**From:** [grands ones](#)  
**To:** [Deb Estrada](#)  
**Subject:** Trees, Secret Park, Neighborhood Traffic  
**Date:** Wednesday, January 24, 2024 12:52:29 PM

8/30/23
 JOB NUMBER:
13-118
 SHEET NAME:
SP-01
 SHT **3** OF **10**

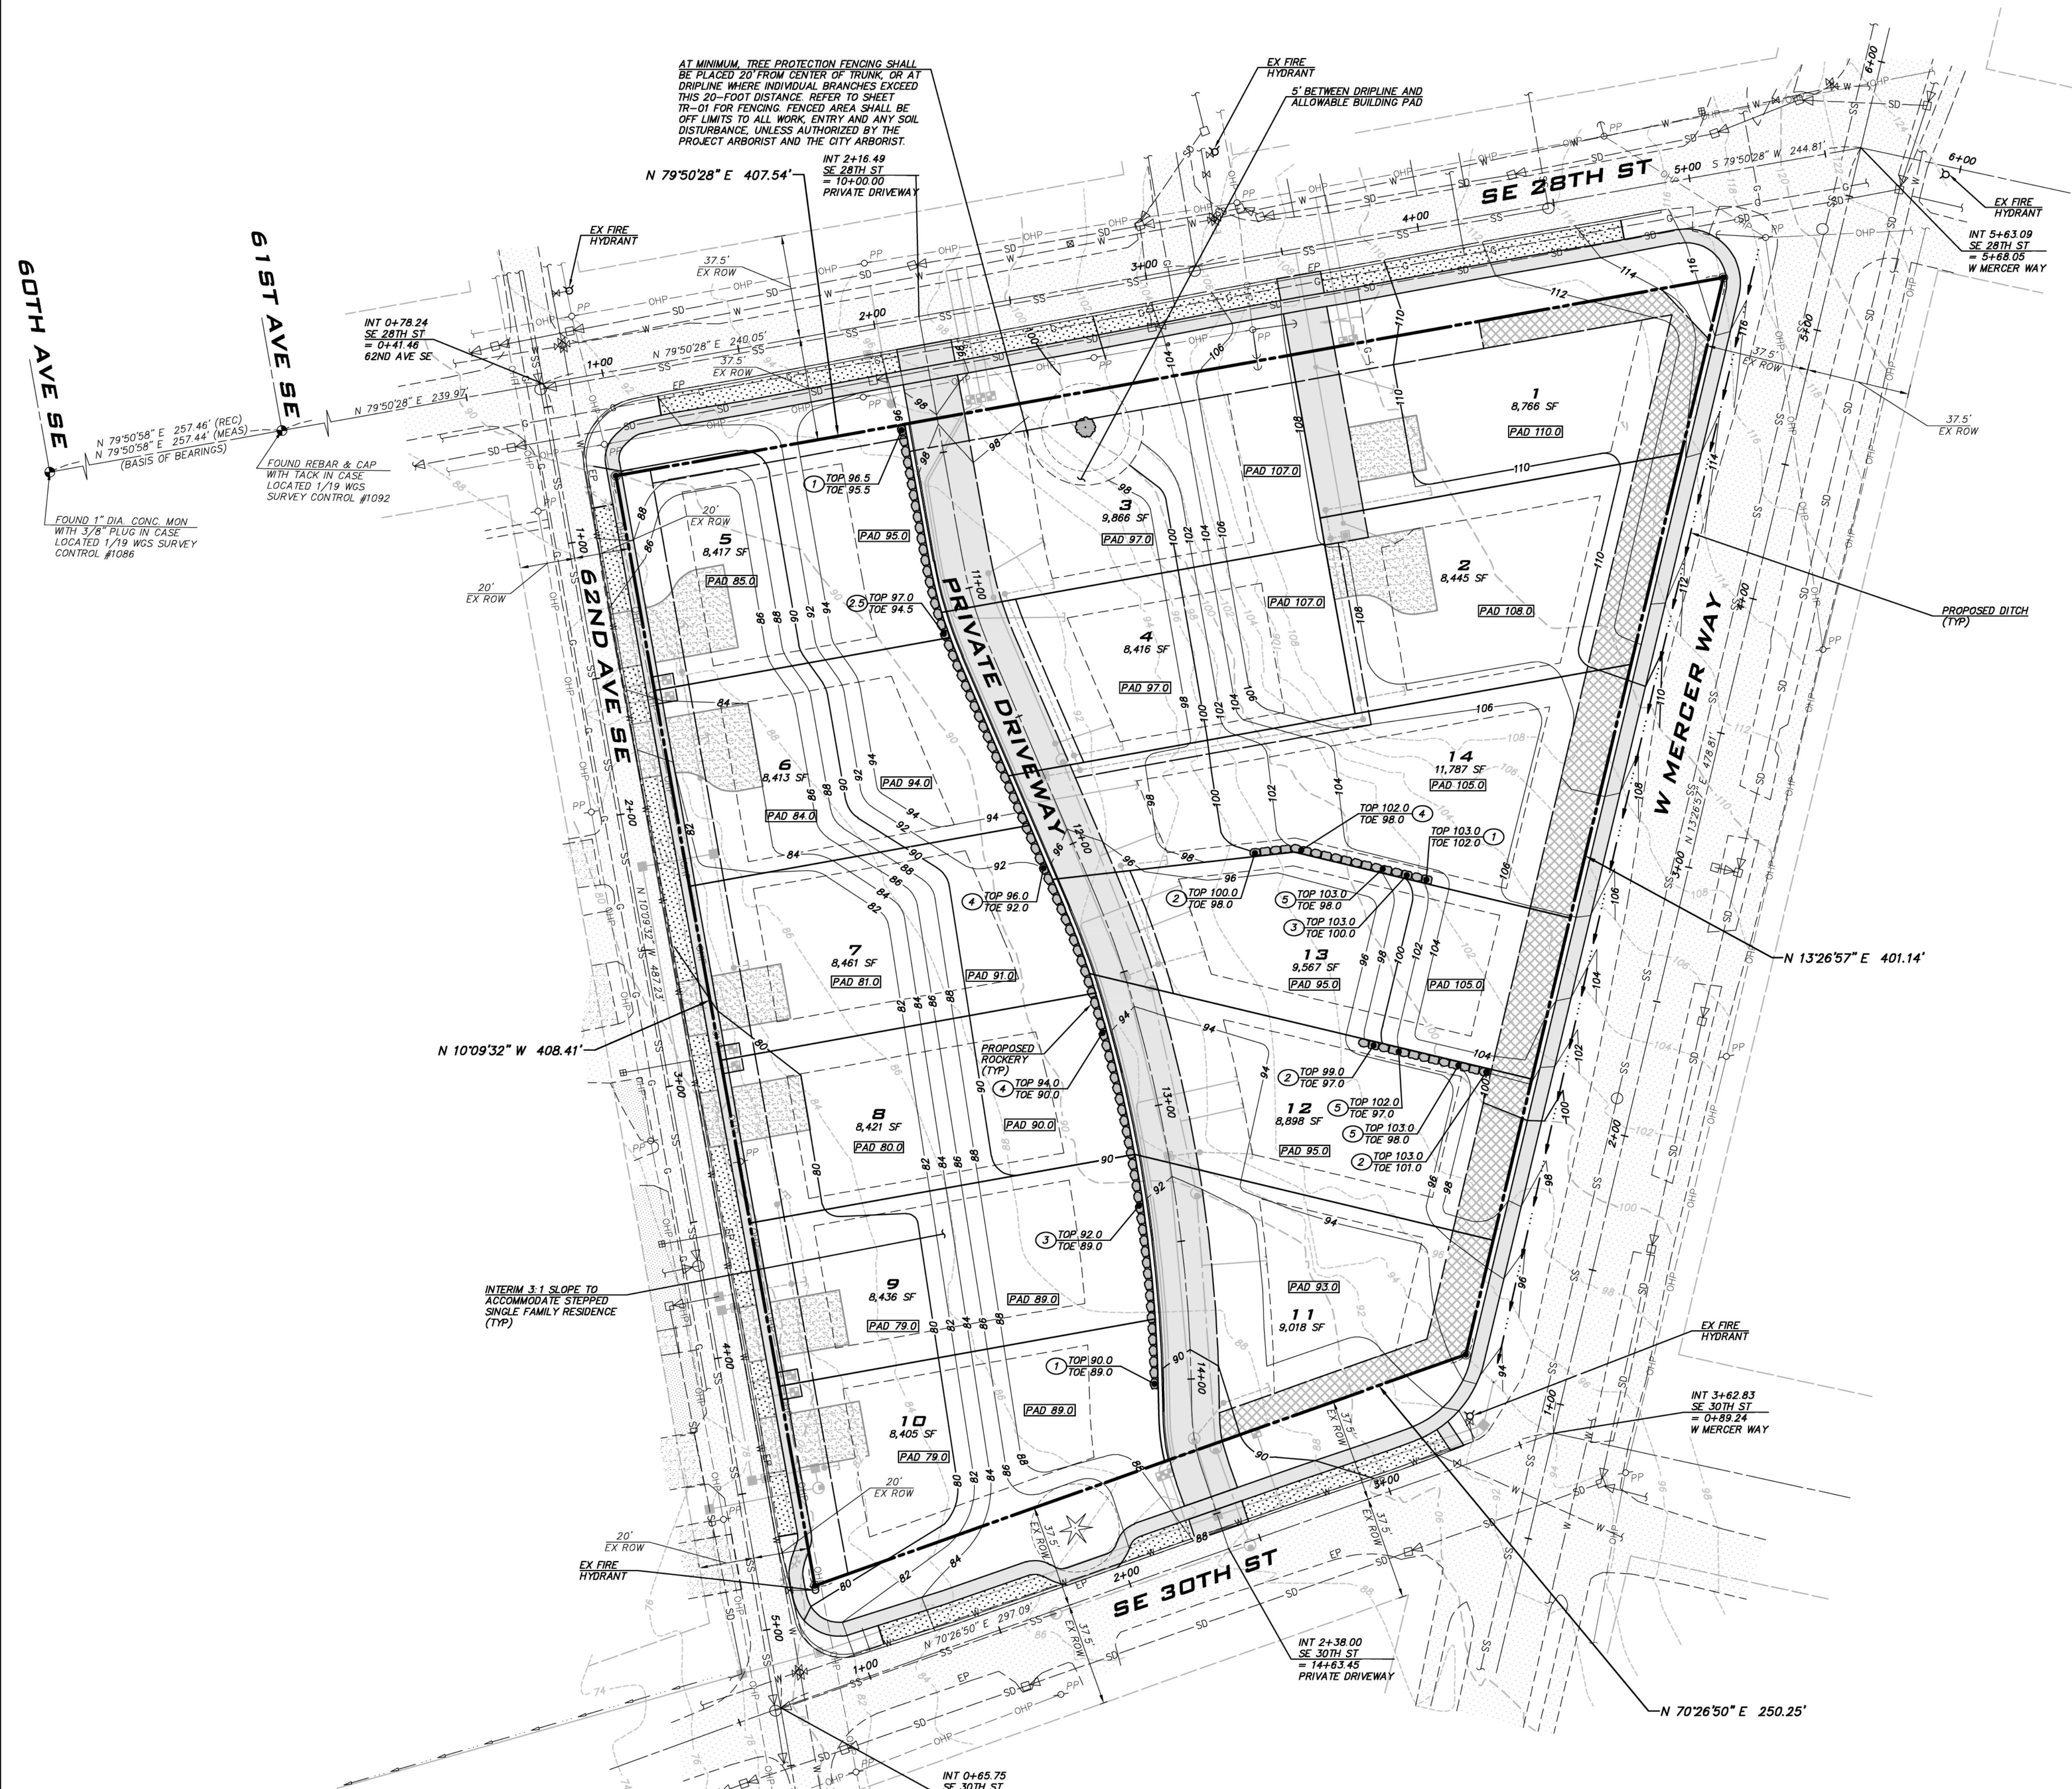
3. Along with other commenters I am concerned about the increased traffic and parking . Two sides of this property are currently characterized by open drainage and meagre on street parking. Why is there no access to the property from the main arterial West Mercer Way? The impact of 6 driveways to 62<sup>nd</sup> St seems grave .

SCALE: AS NOTED
 PROJECT MANAGER:
 BRETT K PUDISTS, PE
 PROJECT ENGINEER:
 LYNDEY FEDAK, PE
 DESIGNER:
 AARON C LANCE
 ISSUE DATE:
 8/30/2023

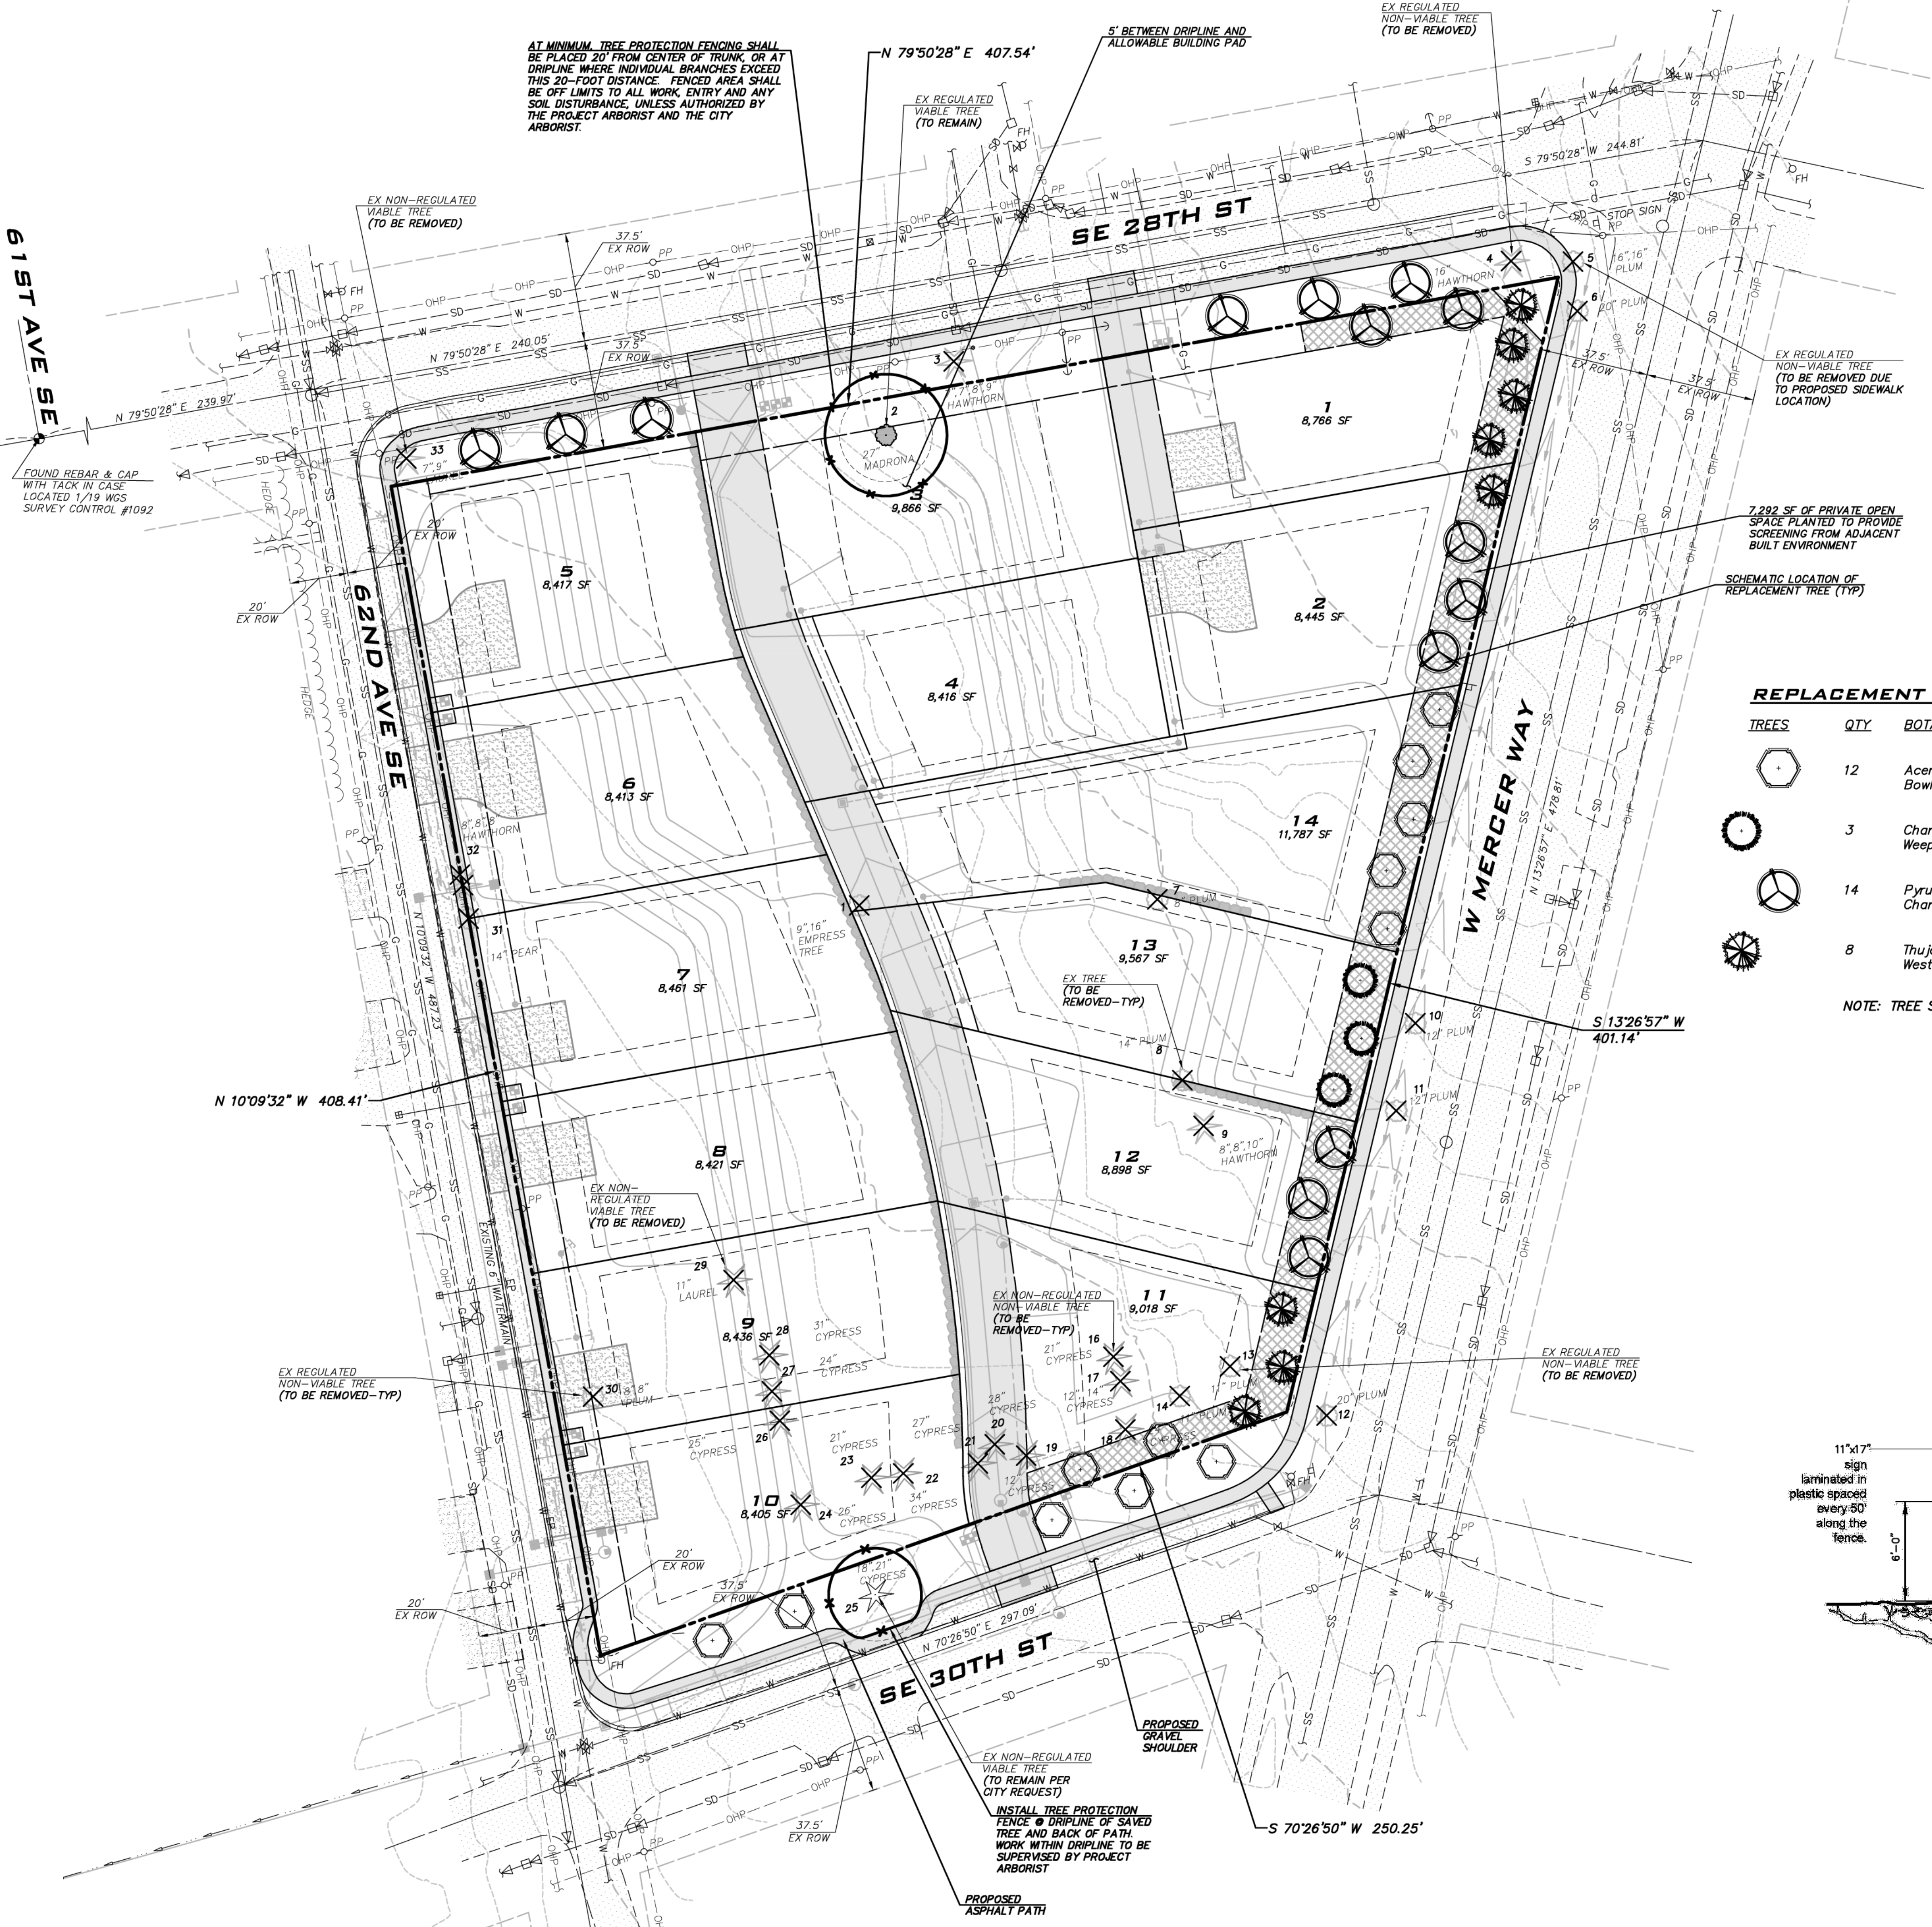
1. This property was until it was taken over by the Boys and Girls Club ,a school . Most of the landscaping is on the periphery of the property and in very bad shape . The trees on the south side of the property were planted at the time of a fairly recent gym development . Although characterized as Leyland Cypress these trees are in fact Austrian Pines and are perfectly healthy . It appears that most will be sacrificed for a planned ‘private lane’ .
